From: Sarah Burrow <Sarah.Burrow@arun.gov.uk>
Sent: 25 August 2021 11:22
To: Planning.Responses <Planning.Responses@arun.gov.uk>
Cc: Maria Tomalova <Maria.Tomalova@arun.gov.uk>
Subject: RE: Planning Consultation on: BE/104/21/PL

Engineers Comments Regarding Surface Water Drainage

Application No: BE/104/21/PL
Registered: 7th July 2021
Site Address: Land Adjoining the Tesco Express 351 Chichester Road Bognor Regis PO21 5AN
Grid Reference: 492246 100784
Description of Works: Erection of 2 No. 2-storey dwellings consisting of 3 No. 2 bed units & 4 No. 3 bed units, access, parking, cycle storage, bin store and other associated landscape works. This site is in CIL Zone 4 (Zero Rated) as flats.

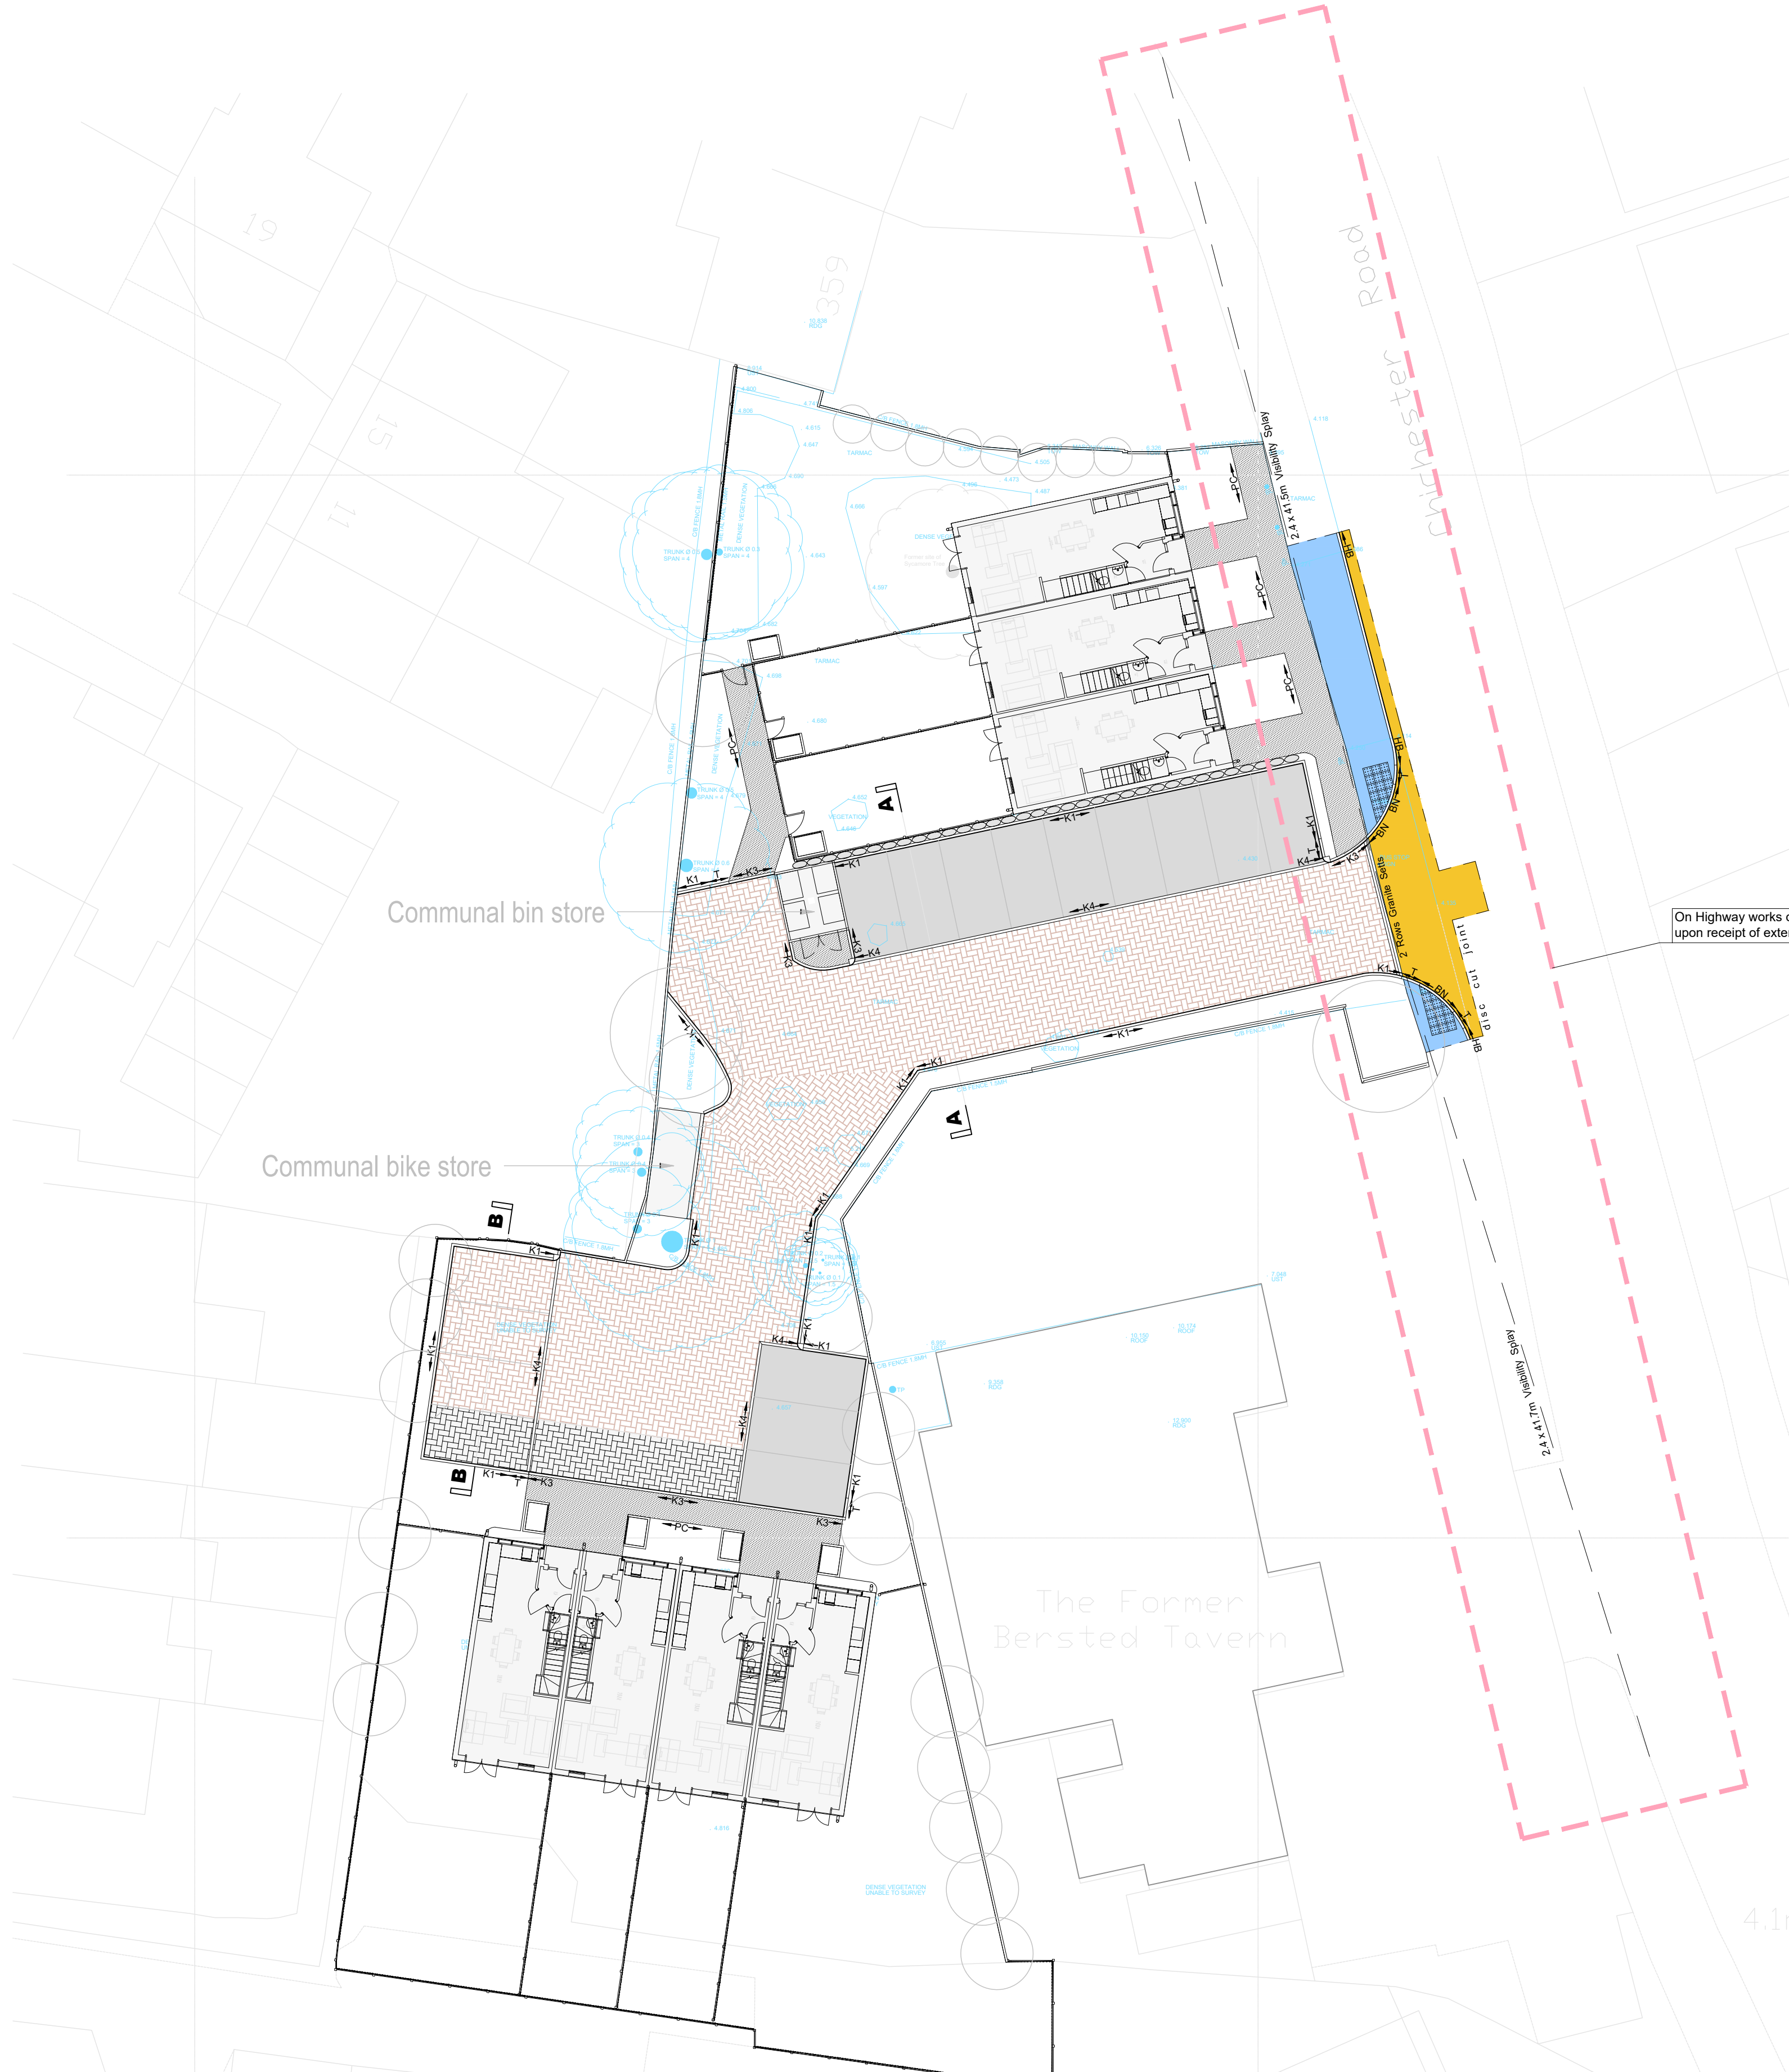
Preliminary ground investigations were carried out on 11/5/2021 which consisted of three windowless sample boreholes and one hand excavated BRE 365 compliant trial pit. Groundwater was noted in all boreholes at a depth of 2m below ground level (bgl) and infiltration testing evidenced an infiltration rate of 5.37×10^{-5} . However, no extended period of groundwater monitoring has been evidenced and no infiltration testing has been undertaken in the winter period. The drainage design for the proposed development must be based upon winter groundwater monitoring and winter infiltration testing.

It is likely that infiltration will be viable on site in which case the proposed strategy of disposing of surface water to ground via a perforated pipe in the (assumed permeable) paved driveway is appropriate. The applicant engineer is encouraged to contact us in advance to agree the level of groundwater monitoring and infiltration testing required (including depths).

If you are minded to approve the application do not list the “Drainage General Arrangements EX.01 RevP1” as an approved document and please apply the following conditions to ensure that the development is adequately drained and does not increase flood risk elsewhere.

“Development shall not commence, other than works of site survey and investigation, until full details of the proposed surface water drainage scheme have been submitted to and approved in writing by the Local Planning Authority. The design should follow the hierarchy of preference for different types of surface water drainage disposal systems as set out in Approved Document H of the Building Regulations, and the recommendations of the SuDS Manual produced by CIRIA. Winter groundwater monitoring to establish highest annual ground water levels and winter Percolation testing to BRE 365, or similar approved, will be required to support the design of any Infiltration drainage. No building / No part of the extended building shall be occupied until the complete surface water drainage system serving the property has been implemented in accordance with the agreed details and the details so agreed shall be maintained in good working order in perpetuity.”
